KITTITAS COUNTY

MEMORANDUM

TO: All Staff
FROM: Public Works Plan Review Team
DATE: March 4, 2025
SUBJECT: BL-25-00004 Brown Rd Estates LLC

BL-25-00004 Brown Rd Estates LLC

SOLAR DOLAR, LLC SITE PLAN

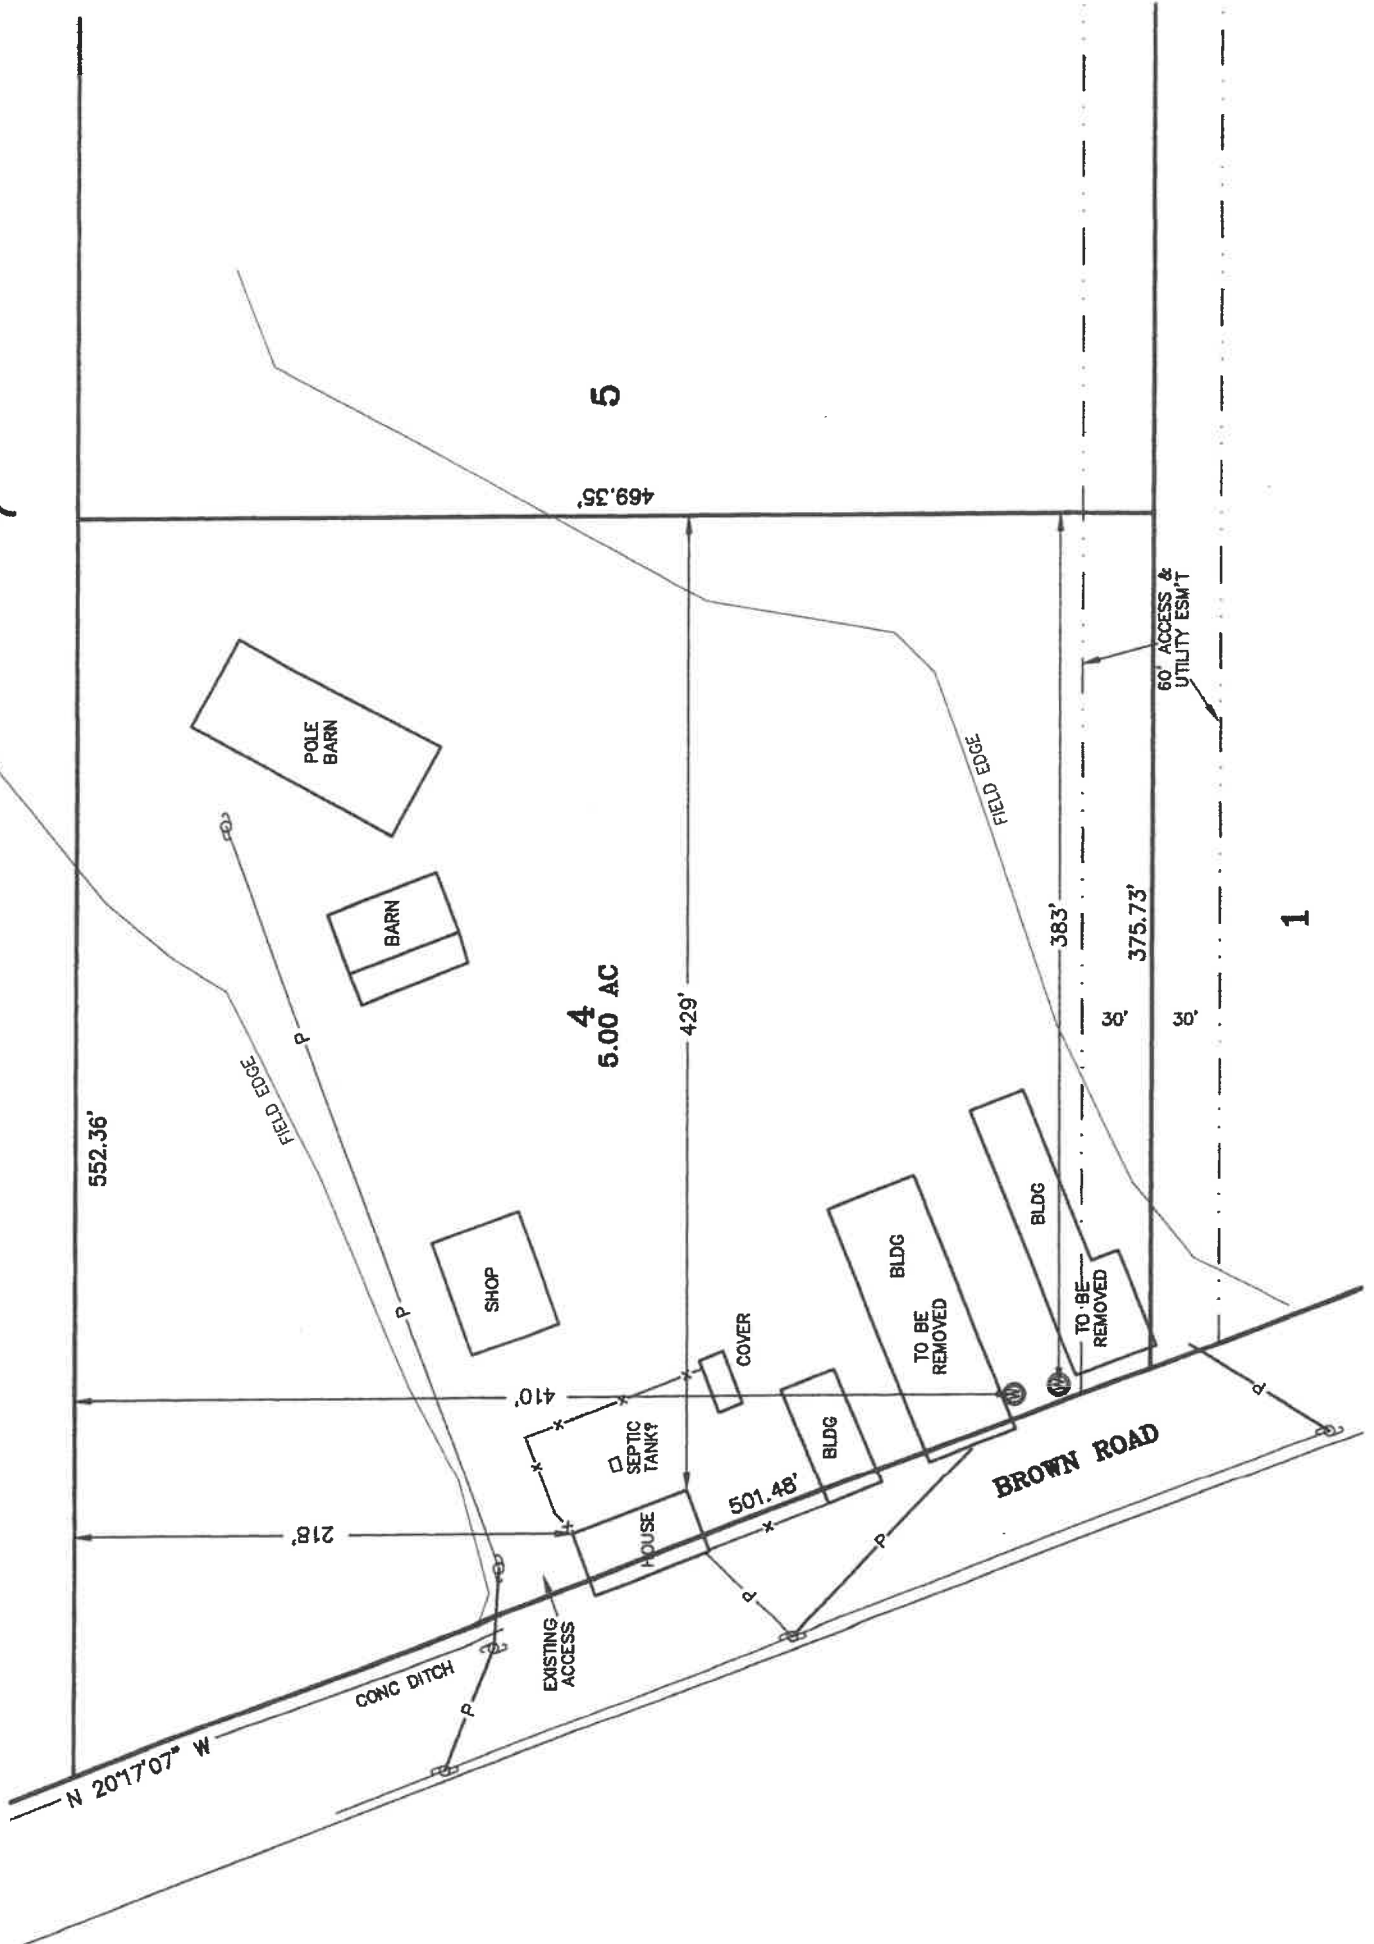
1. For parcels 1,2,3,5, 6, and 7 a soil log will need to be performed to determine the soil type. Soil logs are not the same as site evaluations for septic systems.
2. Submit an adequate water supply determination.

BL-25-00004 Brown Rd Estates LLC Critical Areas

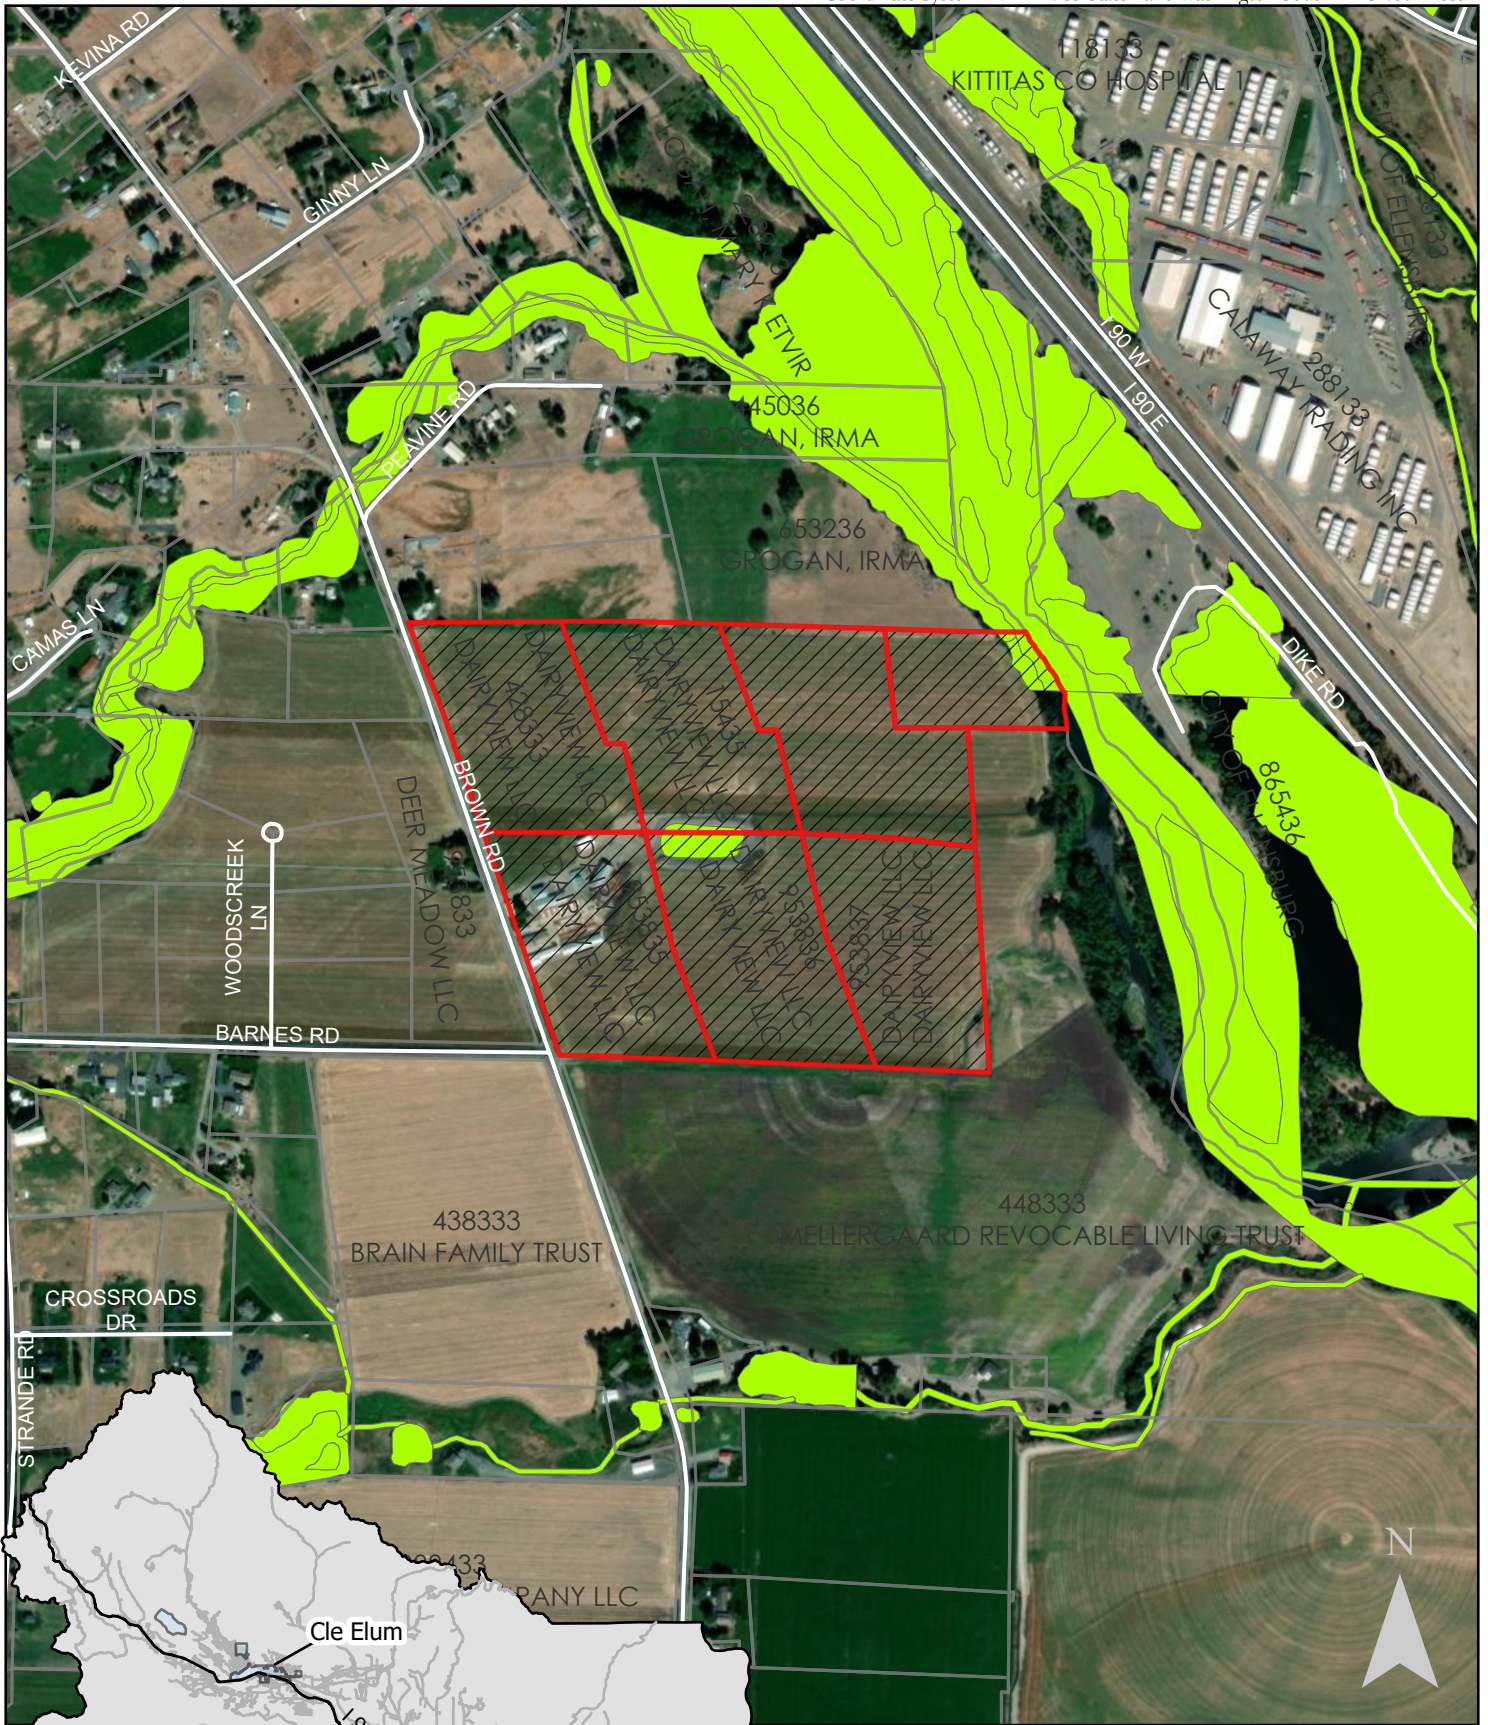
FLOOD	<p>A portion of parcel #618133 is within the FEMA identified special flood hazard area (100-year floodplain and floodway). Please be advised that the floodway is highly restricted and any development within the floodway must be permitted through a floodplain development permit and must demonstrate no rise of 100-year flood elevations before being permitted. No new or substantially improved residences are allowed within the floodway.</p> <p>If possible, any future development should remain outside of the floodplain in order to reduce risk and avoid mandatory flood insurance purchase requirements. All activities within the floodplain must be permitted through the floodplain development permit process and follow the regulations within KCC 14.08. (SC)</p>
WATER MITIGATION/ METERING	No comments. (SC)
AIRPORT	No comments. (JS)
